WELWYN HATFIELD BOROUGH COUNCIL – DEVELOPMENT MANAGEMENT
DELEGATED REPORT

APPLICATION No:	N6/2012/2652/FP
APPLICATION Site:	35 Sherrardspark Road WGC

DESCRIPTION OF PROPOSAL: Loft conversion with dormer window

PROJECT	35 Sherrards Park Road
DRAWING TITLE	Proposed Elevations REVISION D
STATUS	Pre - Planning
SCALE 1:100 @ A3	DRAWN BY AM 08 - 004PD

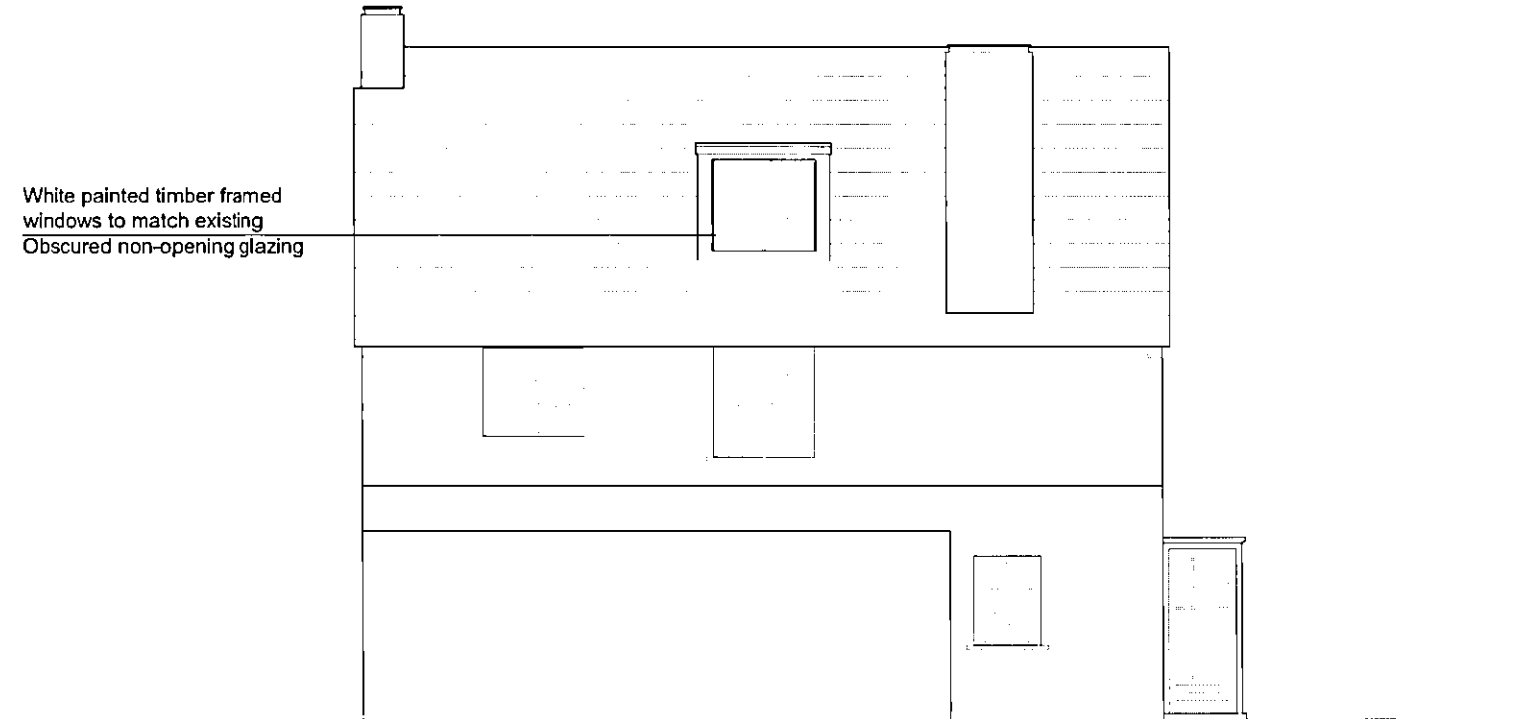
BEAMS : Advise that: 'The general advice to the agent has been to slim down the dormer as far as possible, to seek to achieve a vertical emphasis (rather than being more wide rather than tall- with a somewhat squat appearance within the roof). Aligning the dormer with the width of the first floor window below seems a harmonious approach. The submitted drawings are at a small scale- the elevation of the dormer seems roughly square. Proper detailed & dimensioned drawings should be required to make this point clear & also show the edge detailing of the structure & window frames.'

The design of the dormer will have a lead formed flat roof and leaded dormer checks. The window will be white painted timber to match the existing windows. The Georgian glazed windows panes are of similar proportions to the original windows of the property. The proposed dormer window is also aligned centrally with the first floor window below. This was also a requirement of BEAMS.

BEAMS have also suggested that the proposed dormer appears somewhat 'squat' and roughly square in shape, however, in terms of proportion it is considered the current proposal is appropriate with the rest of the building. In terms of BEAMS also suggesting the submission of further detailed construction drawings, it is necessary to note that the current drawings are well presented and show in accurate detail the detailing of the proposed dormer. As the building is not listed it would be unreasonable to request more drawings through a planning condition where the current application drawings are of an acceptable standard.

There is a requirement therefore to minimise overlooking to No.37 through the design of the dormer. The proposed dormer is centrally located within the roofslope of the application property which means that it will be orientated towards the existing side roofslope of No.37. Direct views will be limited therefore towards the gable end of No.37, although there will be some potential for overlooking to the rear of No.37 from more oblique angles.

The applicant has agreed to have the dormer window obscure glazed and non opening. Such design proposals would ensure that any overlooking that may be possible to towards No.37 would be prevented.

3. The dormer hereby permitted shall be constructed with a lead flat roof and dormer cheeks with a white painted timber framed window. These approved materials shall not be changed without the prior written consent of the Local Planning Authority.

4. The second floor dormer of the proposed extension hereby permitted shall be glazed with obscured glass and shall be fixed so as to be incapable of being opened and shall be retained in that form thereafter.

| DRAWING TITLE | Proposed Floor Plans REVISIOND |

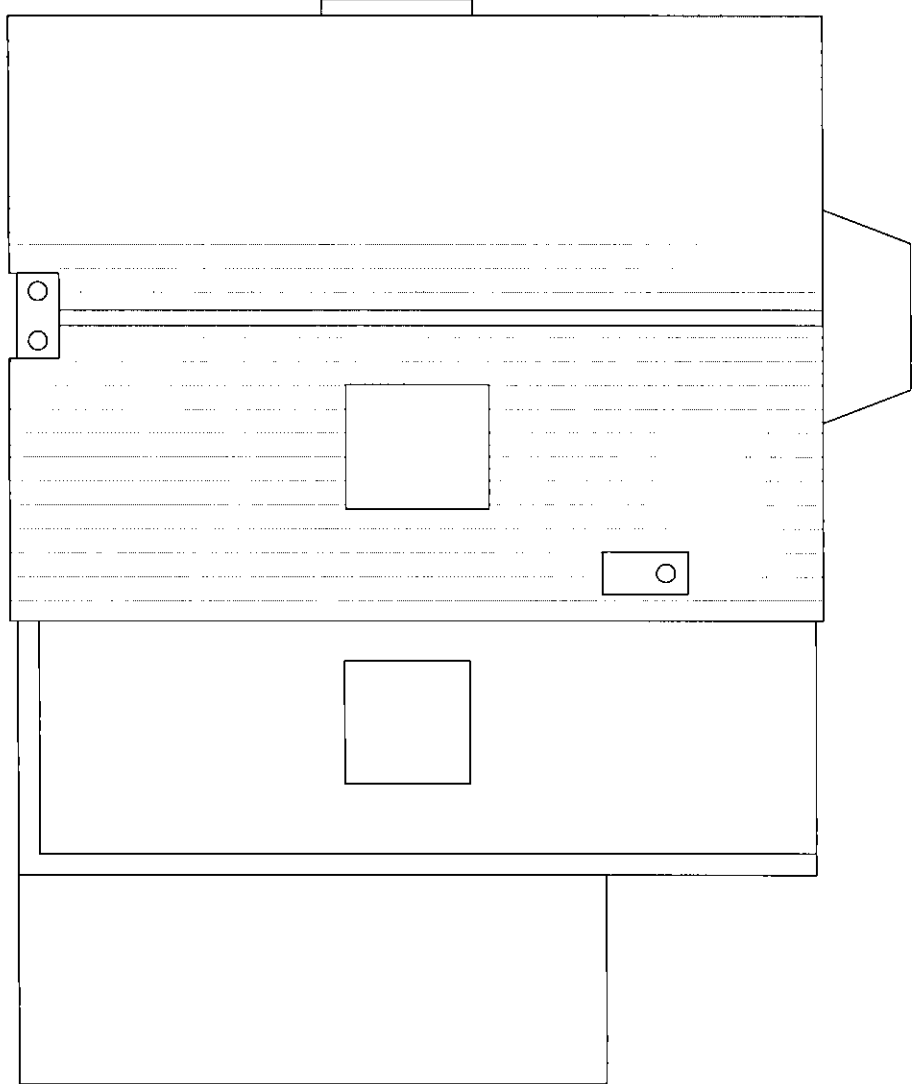
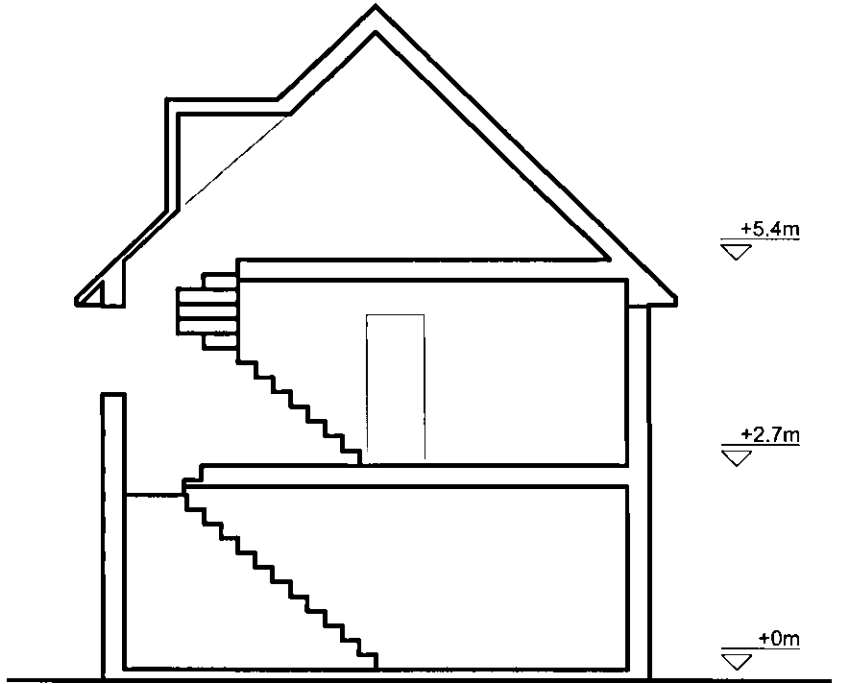
The proposal is to insert a new dormer on the existing roof slope on the south west elevation. This new dormer will be for a new staircase which is required to facilitate the conversion of the loft space at second floor level into habitable accommodation.
